**Section 96A of the Town & Country Planning Act 1990 (as amended)
Town and Country Planning (Development Management Procedure) (England) Order 2015 (as amended) -
Article 10**

Application No: EP/132/21/NMA
Site Address: 27A Sea Lane East Preston BN16 1NH
Description of works: Non-material amendment following grant of EP/2/21/HH for the alteration of front balcony and rear Juliet balcony doors from being single doors with windows either side, to double doors.

Front Elevation (west)

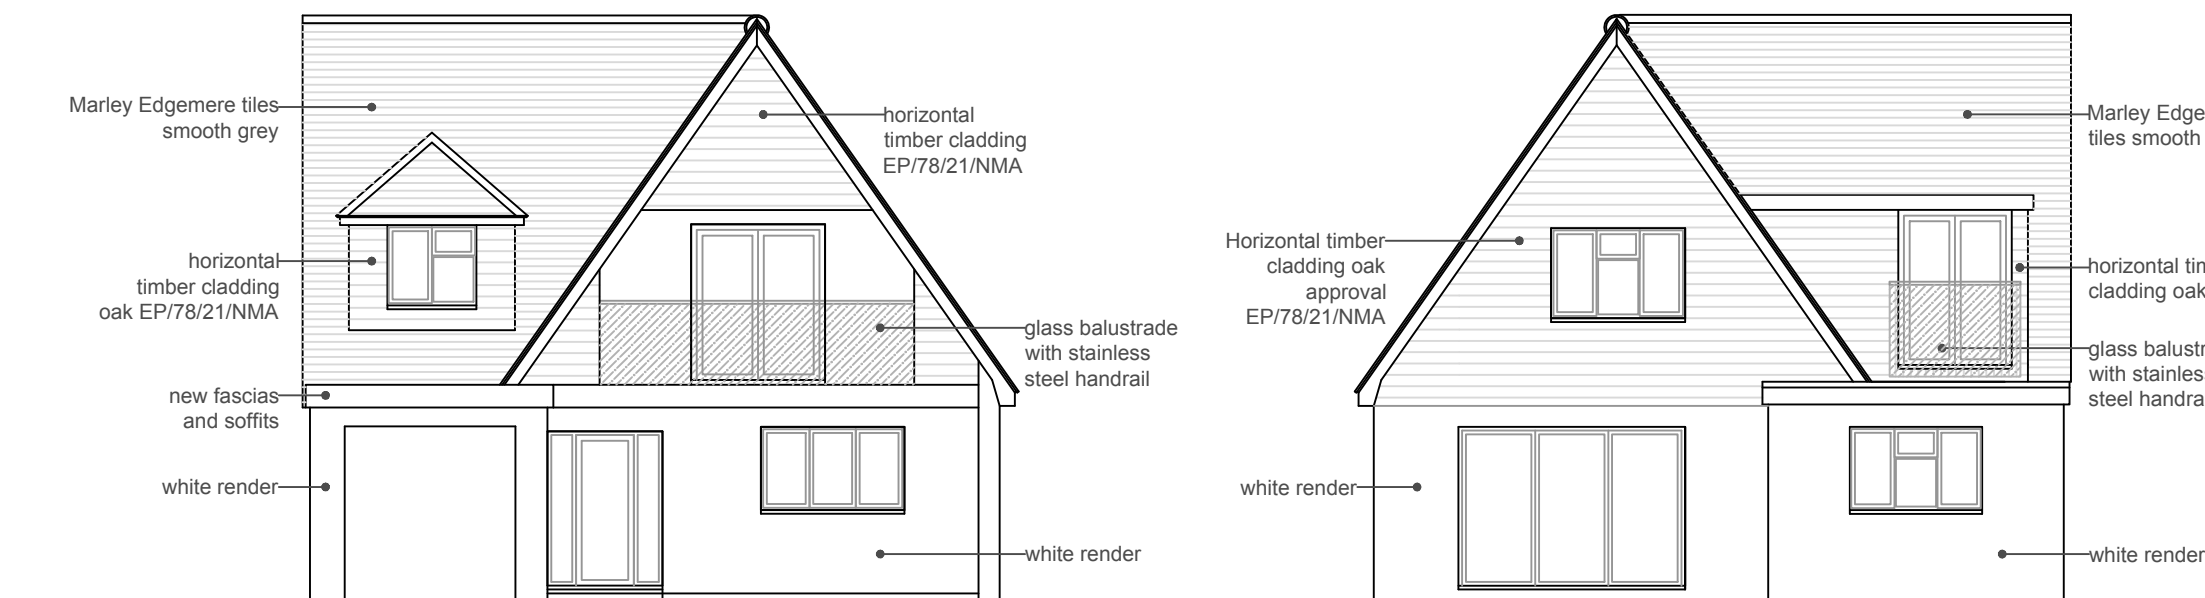
The committee was concerned this Application was being treated as a non-material amendment as it felt the proposed changes were bigger than that.

Rear Elevation (east)

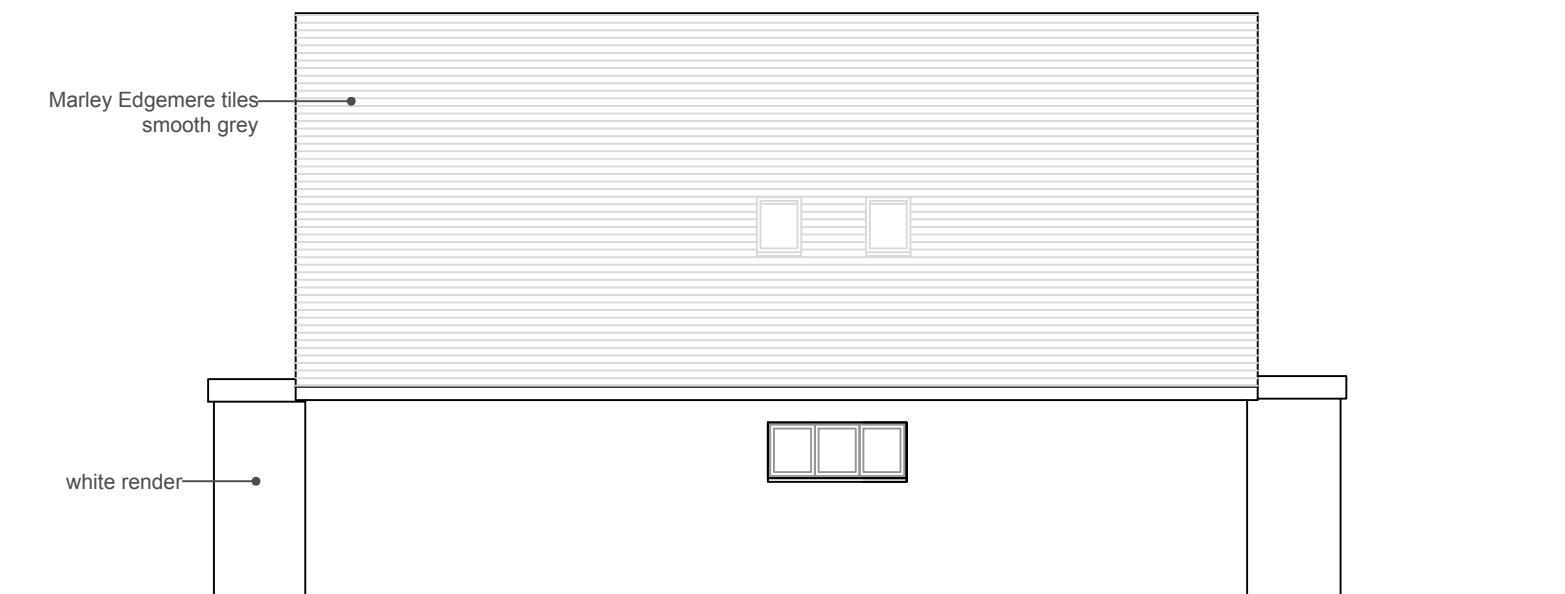
The committee agreed to object to this Application on the grounds the design agreed under EP/2/21/HH was sufficient for the purposes of the Planning Application and had been agreed after objections and concerns had been raised by a number of neighbours. Noting the proximity of a flat roof, the committee was particularly concerned the rear balcony should remain a Juliet balcony with just a single door.
